From: Amanda Scholes on behalf of Planning.Responses
Sent: 01 June 2020 09:03
To: Planning Scanning
Subject: FW: LY/4/20/PL Barn at Broomhurst Farm, Lyminster

From: Info @ Folkes Architects <[REDACTED]>
Sent: 27 May 2020 16:10
To: Anita Gardner <Anita.Gardner@arun.gov.uk>
Subject: RE: LY/4/20/PL Barn at Broomhurst Farm, Lyminster

End 2 Elevation Grid Line 6

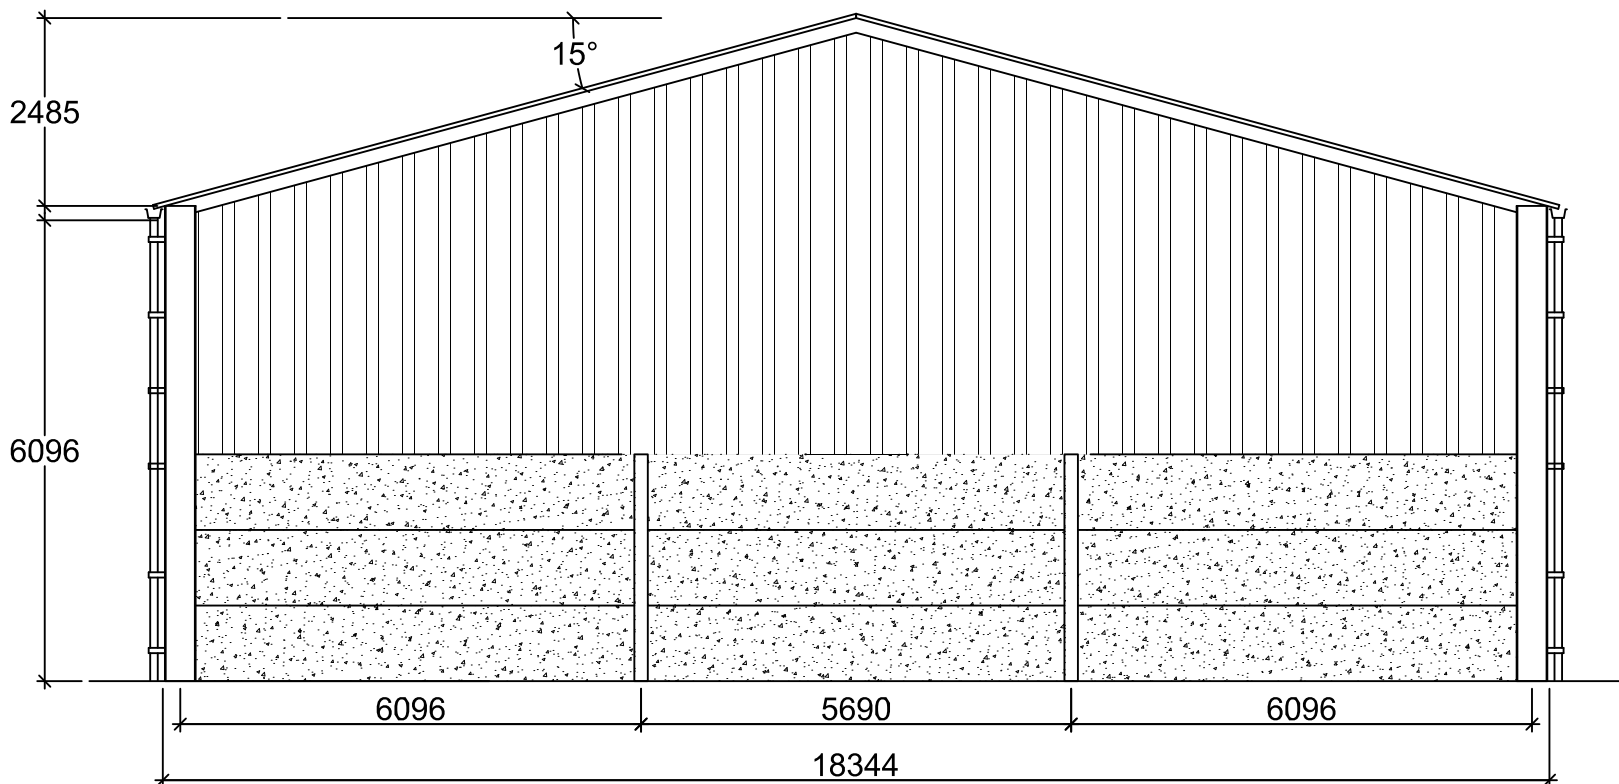
Is there no option to reduce the width/length of the building slightly so that tree planting can be included within the red edge? Or to move the building forward or sideways within the red edge? A reduction in size would help to address our concerns and those of the Parish.

Dear Mark,
I have reconsulted the Ecologist based on the details submitted and await her response. In the meantime I would appreciate receipt of a revised site plan indicating the provision of native planting along the south elevation of the barn.
Regards
Anita

I have spoken to our client and he is agreeable to planting native species to the south of the barn. Can this be treated as a planning condition?
